HUNTER INDOOR SPORTS CENTRE (SSD-65595459) - 24 WALLARAH ROAD & 2 MONASH ROAD NEW LAMBTON

I refer to the Department of Planning, Housing and Infrastructure's (DPHI) request of 14 October 2024 via the NSW Major Projects Portal inviting City of Newcastle (CN) to provide advice on the development mentioned above. I also refer to CN's letter of 11 November 2024 which provided preliminary advice.

The exhibited Environmental Impact Statement (EIS) and architectural plans have been reviewed by CN officers and the following advice is forwarded for your consideration. We recommend the Applicant (Basketball Association of Newcastle Limited) is required to respond to those matters, where indicated:

FIGURE C2 – TREE IMPACT ASSESSMENT DIAGRAM [BASE DRAWING SOURCE: EJE ARCHITECTURE & GROUNDWELL]

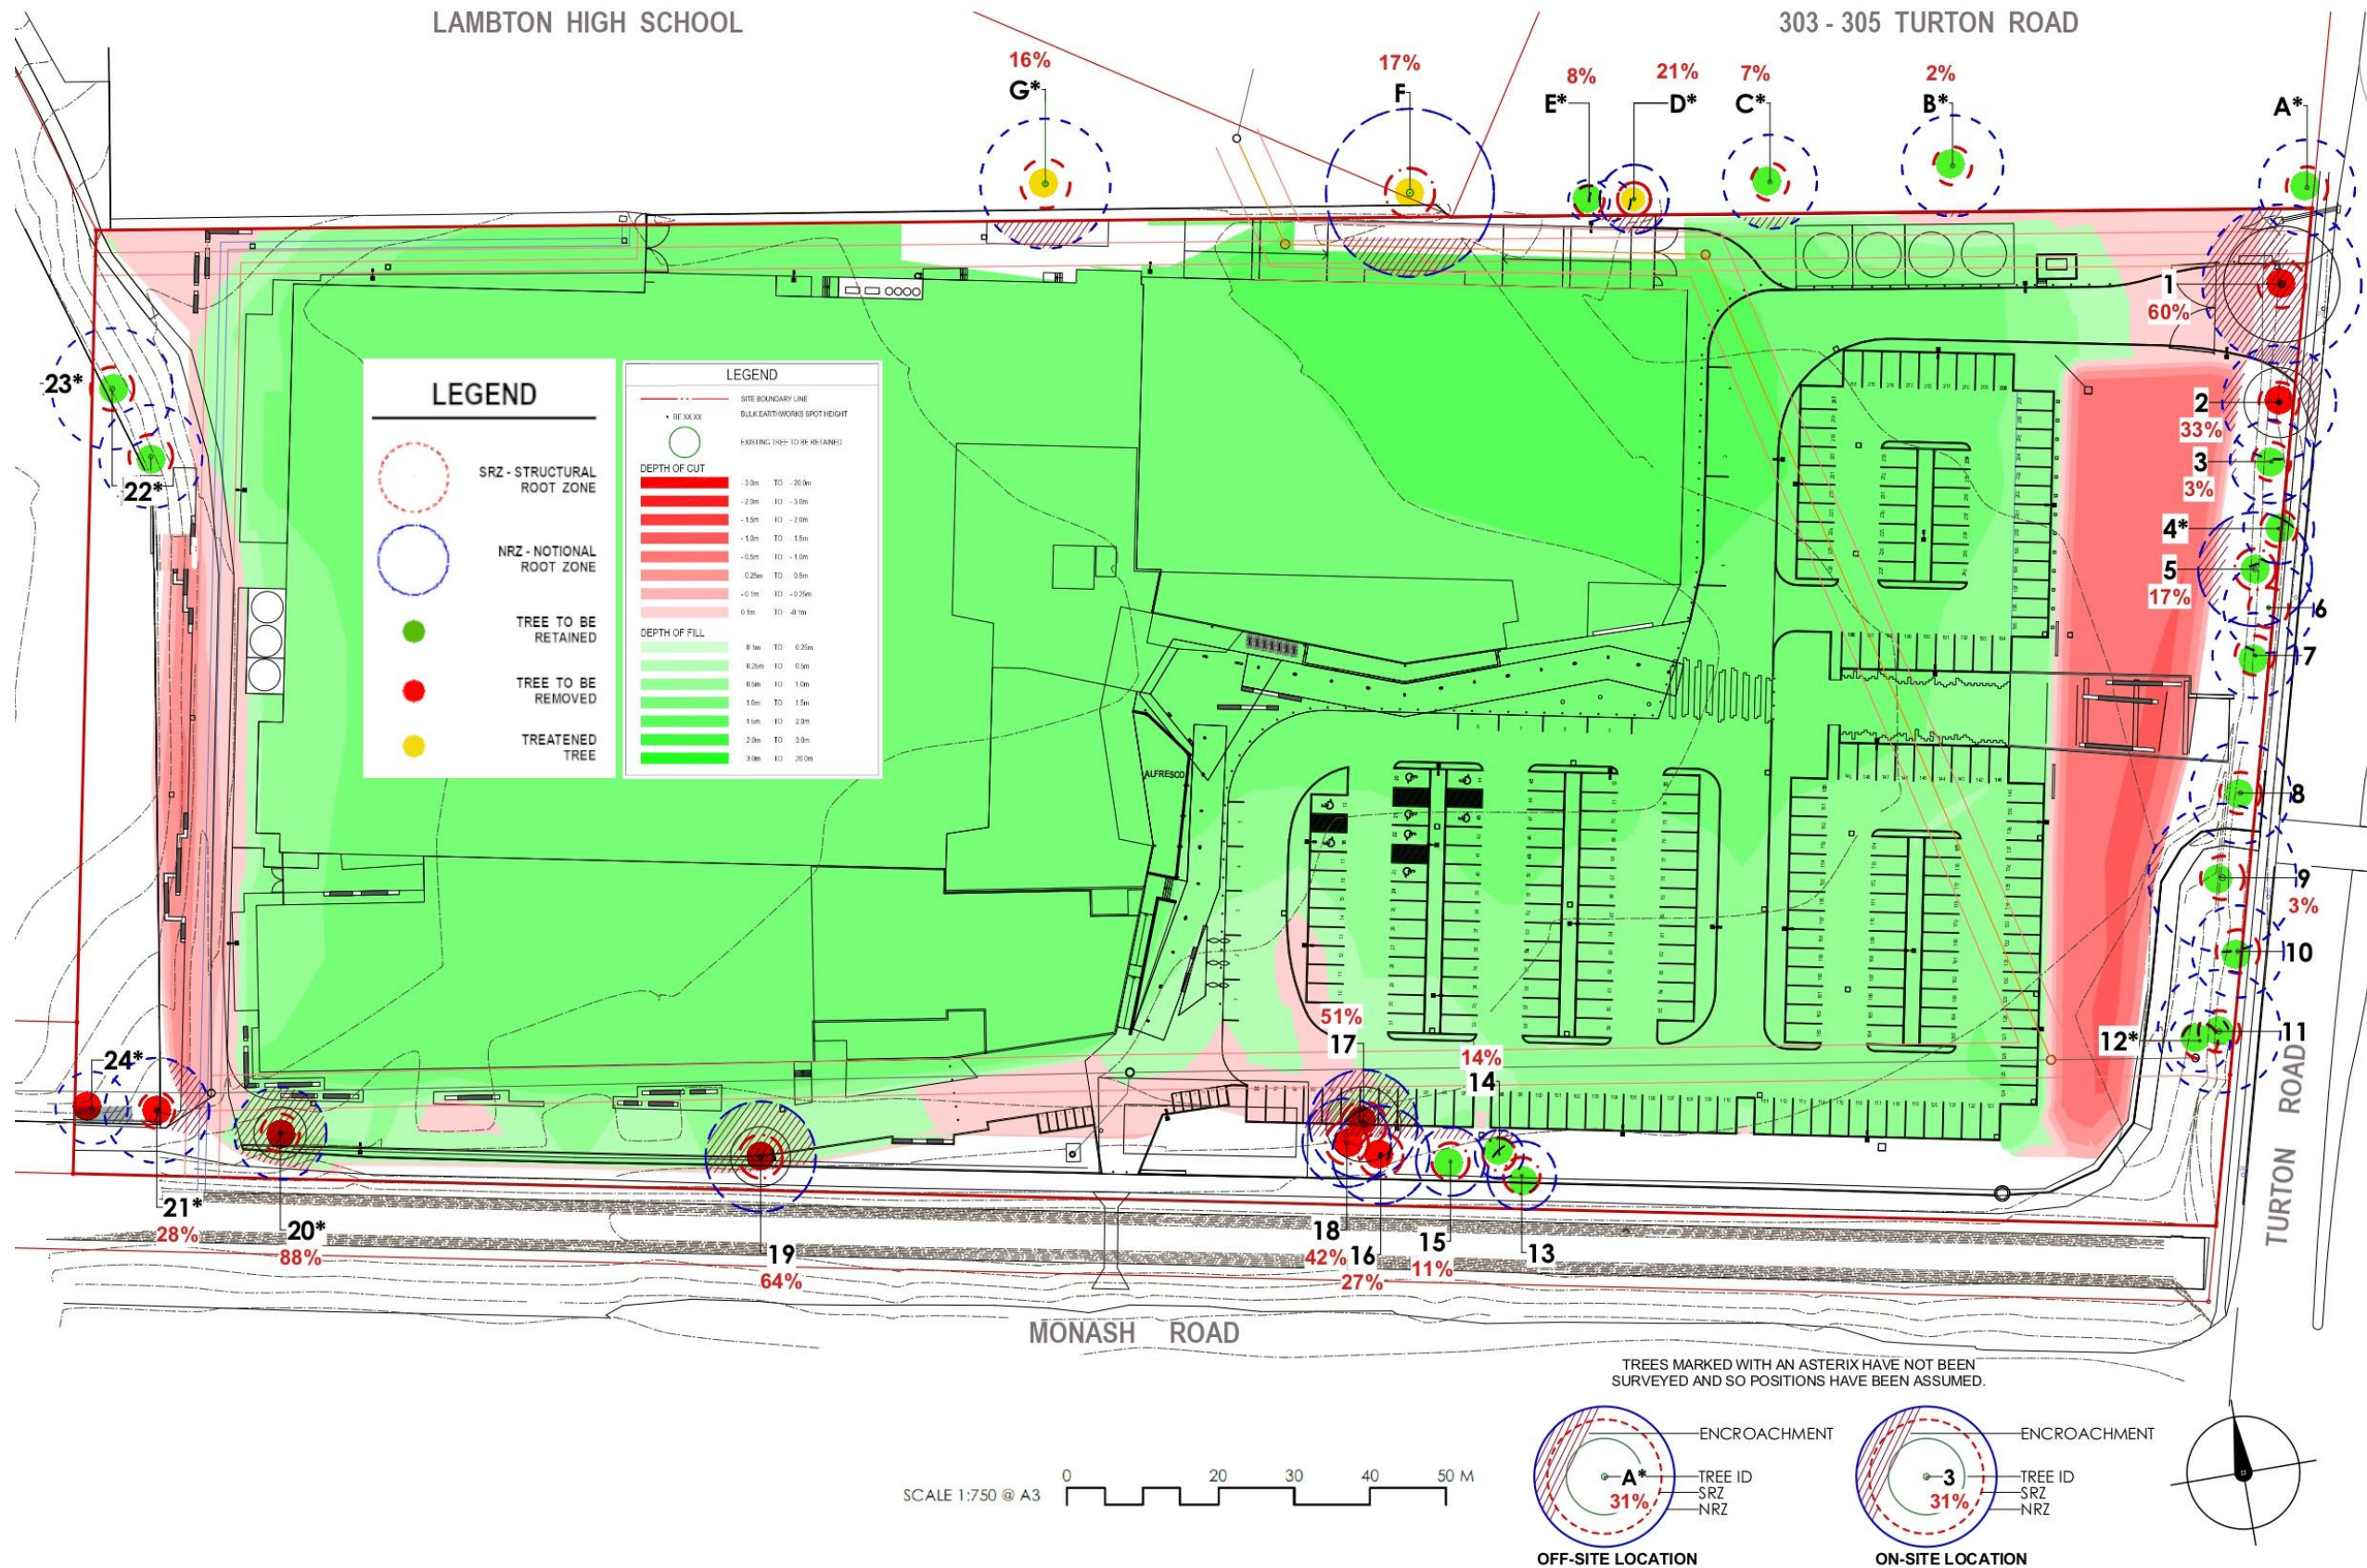
According to the Arboricultural Impact Assessment report (Appendix N), six public trees, including five along the Turton Road frontage, are proposed to be removed to facilitate the development. CN notes all the trees are located on the perimeters of the site and suitable space is available to incorporate most of the trees into the design of the development.

The exception is the removal of a tree to provide vehicular access off Turton Road, which is accepted on traffic safety grounds. Further, as discussed below in 'Point 4-Wind Impacts', achieving suitable wind conditions for the development is dependent on retaining the existing trees along Turton Road.

Amendments to the design of the development should be undertaken in order to retain the trees within the Turton Road reserve.

4-6

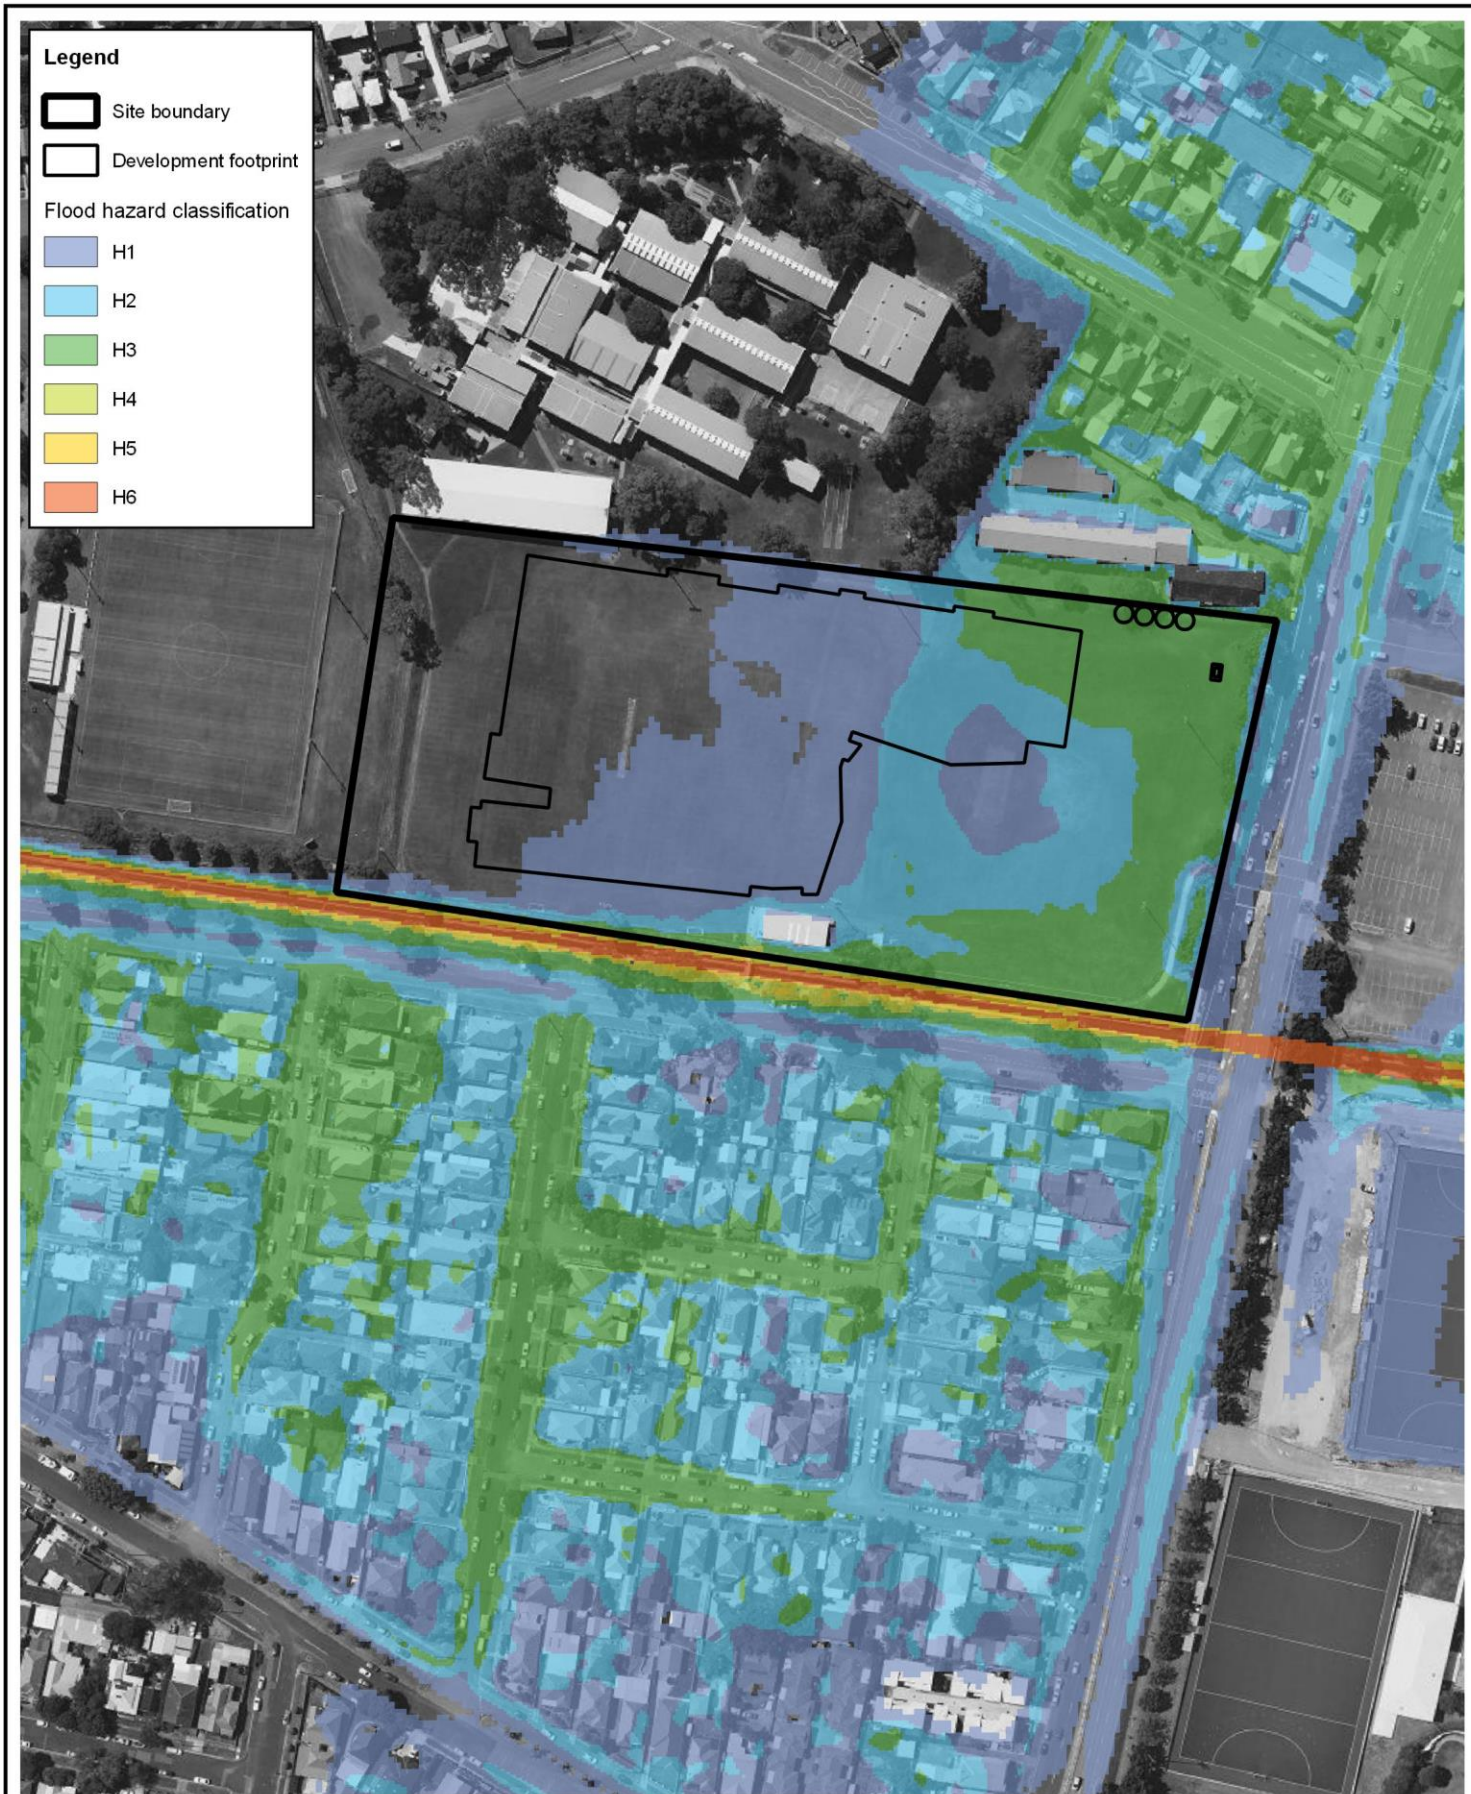
CN has reviewed the pre- and post-development PMF hazard mapping (Figure 4-8 and Figure 5-7 of the FIRA) and found the impact of the proposed development was not limited to public roads. It was noted that, in the modelled post-development PMF scenario:

- i. Flood hazards at the south of Lambton High School (85 Womboin Road) have generally increased along with the extent of the PMF over the site.
- ii. Existing H2 hazard areas in residential properties on Hobart Road, just west of Hitchcock Avenue, become H3.
- iii. Flood hazards at the south of Arthur Edden Oval had generally increased.
- iv. Flood hazards at the Newcastle International Hockey Centre (1/330 Turton Road) have generally increased.

CN recommends the FIRA is amended to address all significant off-site changes to flood hazard at the PMF event due to the proposed development. Additional mapping is also to be prepared highlighting the impact of the proposed development on peak flood hazards in all modelled events - i.e. comparing Figures 4-6 to 4-8 and Figures 5-5 to 5-7.

5-5

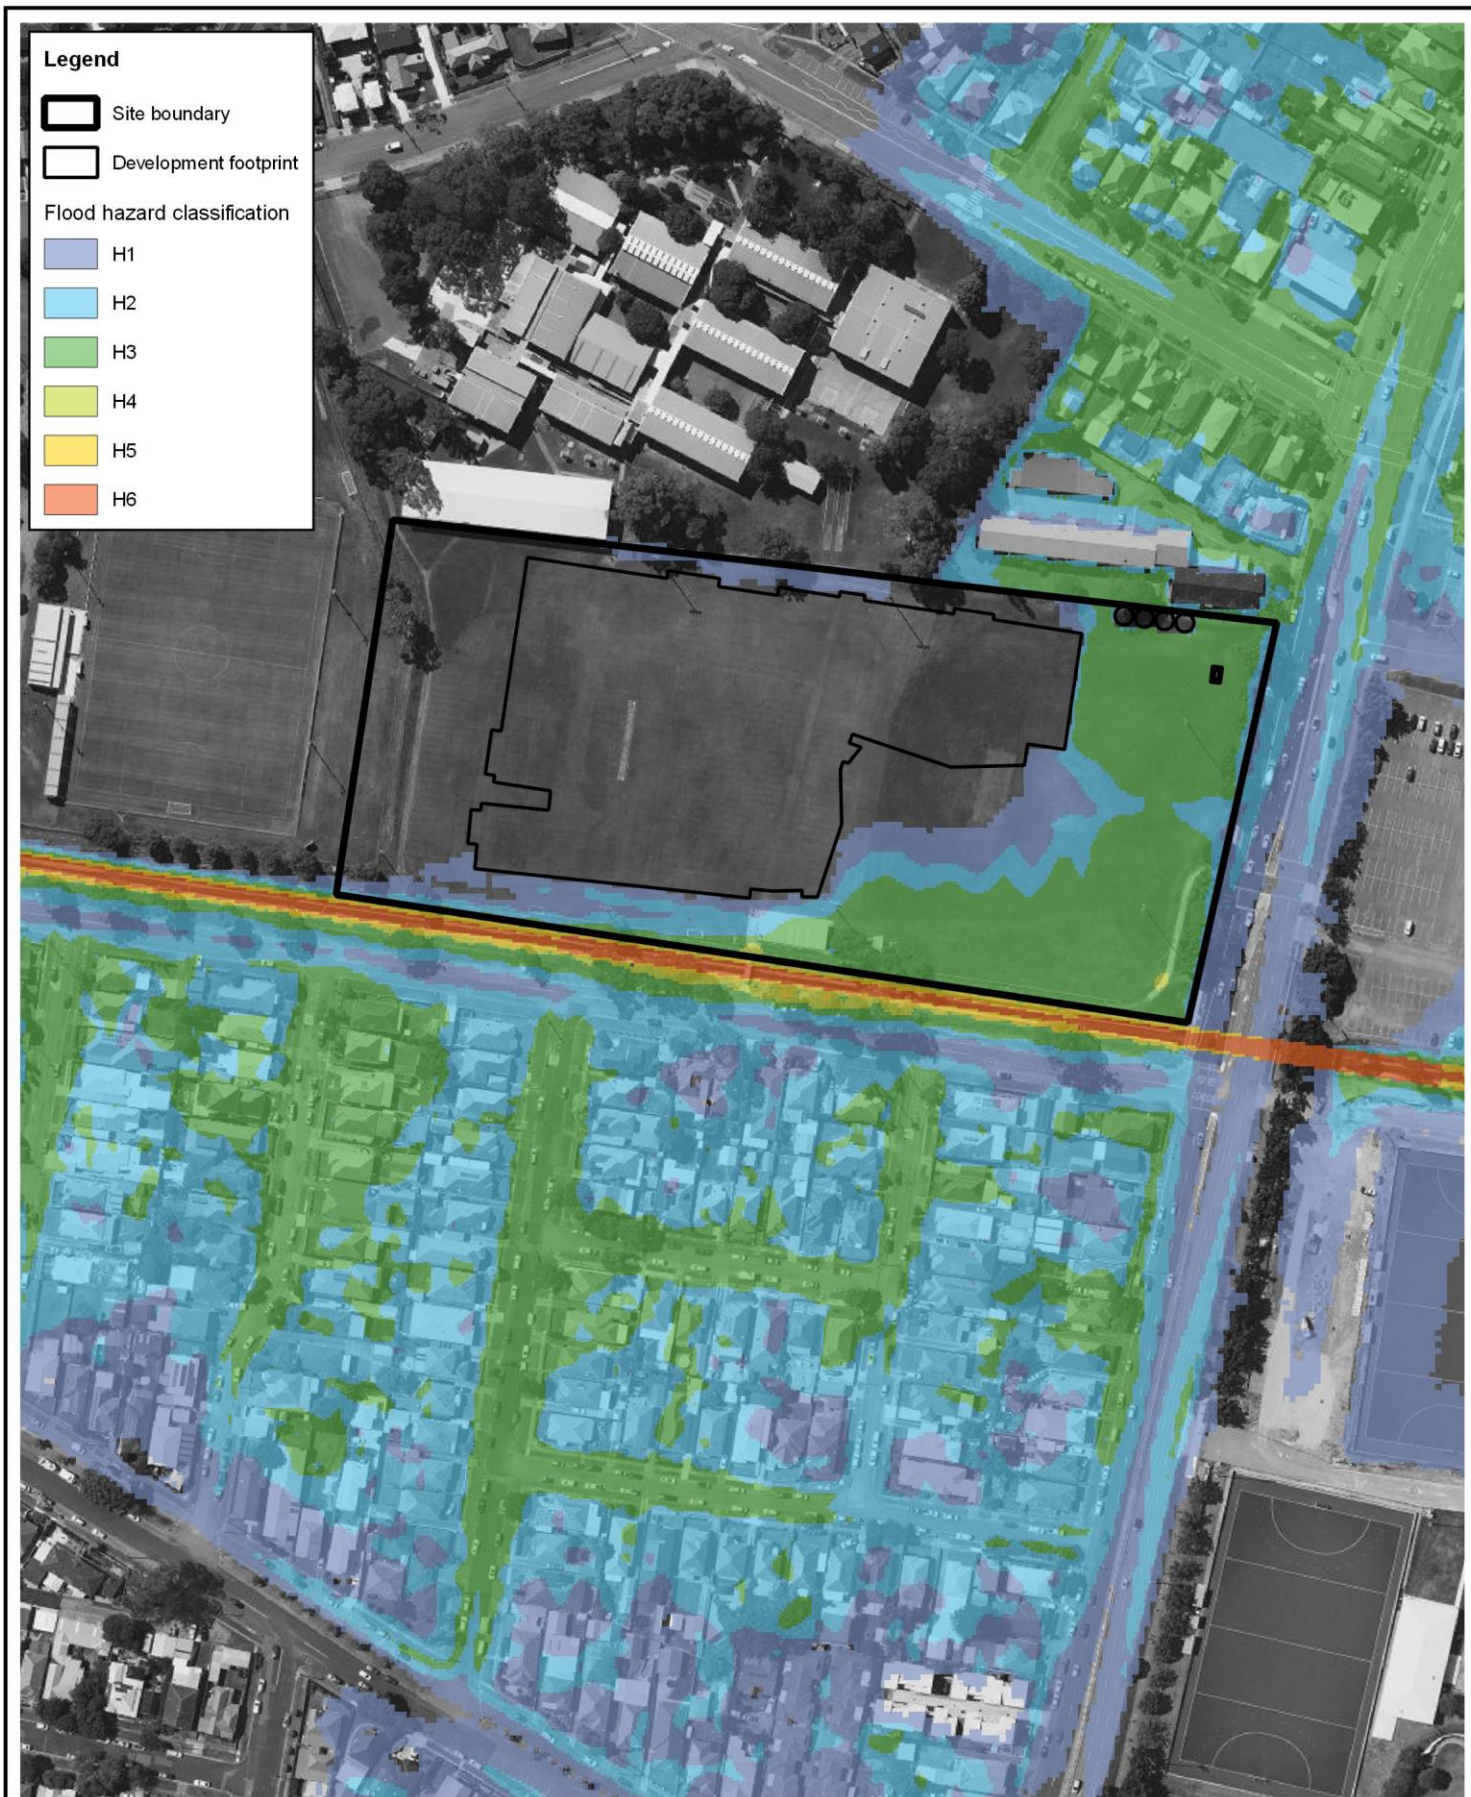
- e. *Proposed car parking in high flood hazard areas* - Figures 5-5 and 5-6 of the FIRA indicate peak flood hazards in post-development conditions for the 10% AEP and 1% AEP 2050 flood events, respectively. CN notes the carparking areas of stages 1B and 2 and parts of 1A are affected by flooding at a hazard level of H2 and H3 during these events. In accordance with Control 8.0(C-7), CN does not generally consider carparking facilities to be suitable in areas subject to flood hazards greater than H1.

It is also noted that at the modelled 10% AEP event, a high number of car parking spaces are affected by H3 and H2 flood hazards. Considering the intermediate frequency of the 10% AEP, CN is concerned the parking of vehicles in these areas will result in flood risks to property (including private vehicles).

The proposed car parking areas in the front setback of the development (Stage 1B and Stage 2 carparking areas) are not compatible with the flood hazard of the land. CN recommends that the development be revised such that no carparking facilities are provided in these areas and these areas remain usable open space.

- i. Redesign or provision of additional fill such that the Stage 1A car park is not exposed to flood hazards greater than H1 during the modelled 1% AEP 2050 flood event. Any additional filling will need to be supported by revised flood modelling.
